Recommendation: Approve

Applicant: Banbury Plant & Skip Hire

Proposal: Reinforcement to northern site boundary to improve security to Ferris Hill Farm (Bund with tree planting and hedge)

CAM/2/146  
MAY 2022

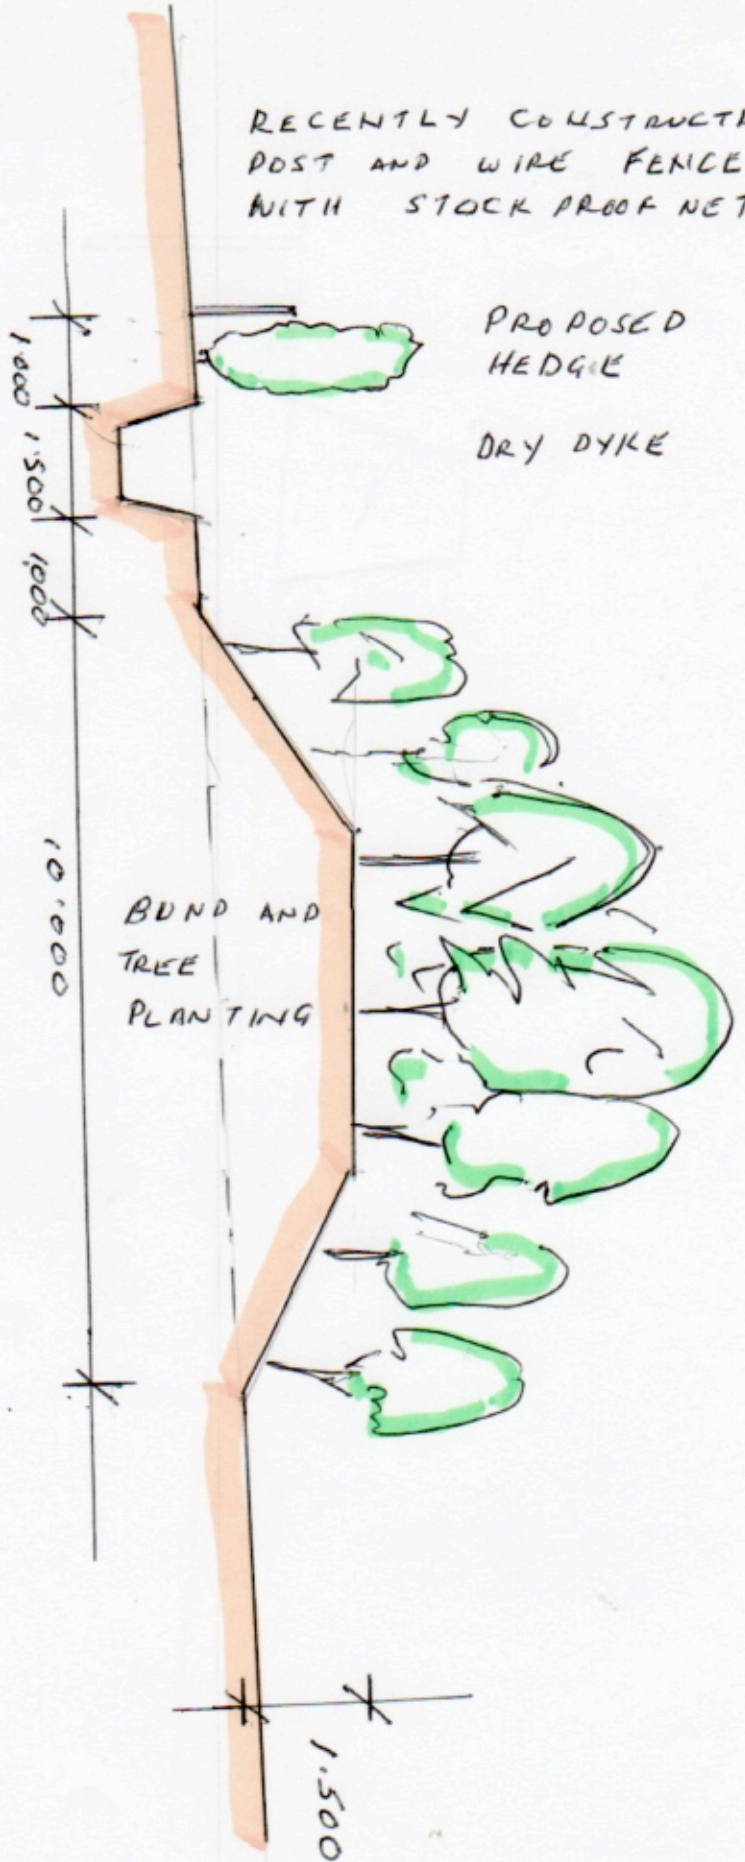
- 8.13. There are no particular objections to the proposed security solution which has been submitted as part of this application. The development would include a low-level post and wire fence with a large hedgerow behind, dry dyke and a 1.5m-high bund. Planting would also be included to the top of the bund to further reduce its visual impact and to help it blend into the countryside beyond.

- 8.14. Whilst the post and wire fence would be a new feature to the area and one that is not generally seen in this locality, it is considered to be an appropriate option for use within the site as a plant and skip hire, this material is often used within agricultural settings for security and as such this isn't considered to be out of keeping with the character and appearance of the locality. An appropriate colour should be chosen for this fencing to ensure it blends into the site and the soft landscaping beyond.

- 8.15. Any impact from the palisade fencing would be softened through the use of an additional hedgerow beyond. Once this hedgerow matures, it would grow around the fencing and would act as further camouflaging.

- 8.16. Wider views to the boundary would see the 1.5m bund and planting as the most prominent feature along this boundary, particularly after the fencing is screened by the hedgerow. Boundaries to the northeast of the site include the use of trees and hedging, so further use of trees on top of the bund would not impact on the existing rural and agricultural character of the site. Trees planted should match those already evident within the locality to ensure the character of the area is retained and continued.

- 8.17. Any harm to the rural aesthetic of the locality through the use of palisade fencing would be partially outweighed by the increase in the security of the site and reducing potential crime within this rural area.
